# OXFORDSHIRE COUNTY COUNCIL'S RESPONSE TO CONSULTATION ON THE FOLLOWING DEVELOPMENT PROPOSAL

**Application no:** 23/03073/HYBRID

**Proposal:** In FULL, the construction of an 82-apartment affordable extra care home (C2 use class) with associated openspace / green infrastructure, landscaping, car / cycle parking, service infrastructure (drainage, highways, lighting), engineering operations, creation of new vehicular access and re-instatement of existing access to footpath, and in OUTLINE, the construction of up to 14 residential (C3 use class) dwellings with associated landscaping, service infrastructure (highways, drainage, lighting)

**Location:** Phase 2 SW Bicester Kingsmere Parcel R East Of, Ludlow Road, Bicester

Drawing No: 21413-CWA-BC-XX-DR-A-2011

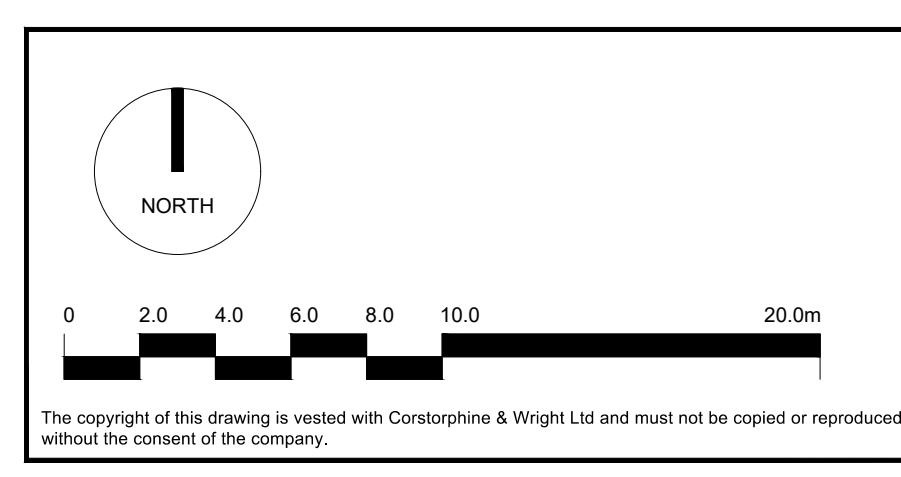
The amendments to the layout plan in relation to aisle widths in order to better facilitated two-way vehicle movement is noted.

**A pedestrian / cycle link to the northwest of the site (near the turning head / substation), connecting to the residential access should be provided / suitably conditioned.**

**It is noted that the trees are proposed to be located outside of the visibility splay. It should be conditioned that the visibility splay should be free of obstructions 2m high down to a point 600mm above the carriageway.**

**The OCC Highways Agreement team have requested the specific plans detailed in the Road Safety Audit (dwg no. 21413-CWA-BC-XX-DR-A-2011 P15).**

**The drawing contained within the revised note is revision reference P25 not P15. There is also another plan with revision reference P26. Clarification is sought as to the final plan version. Without seeing the plans used within the audit they are unable to confirm / agree with the outcomes of the audit.**
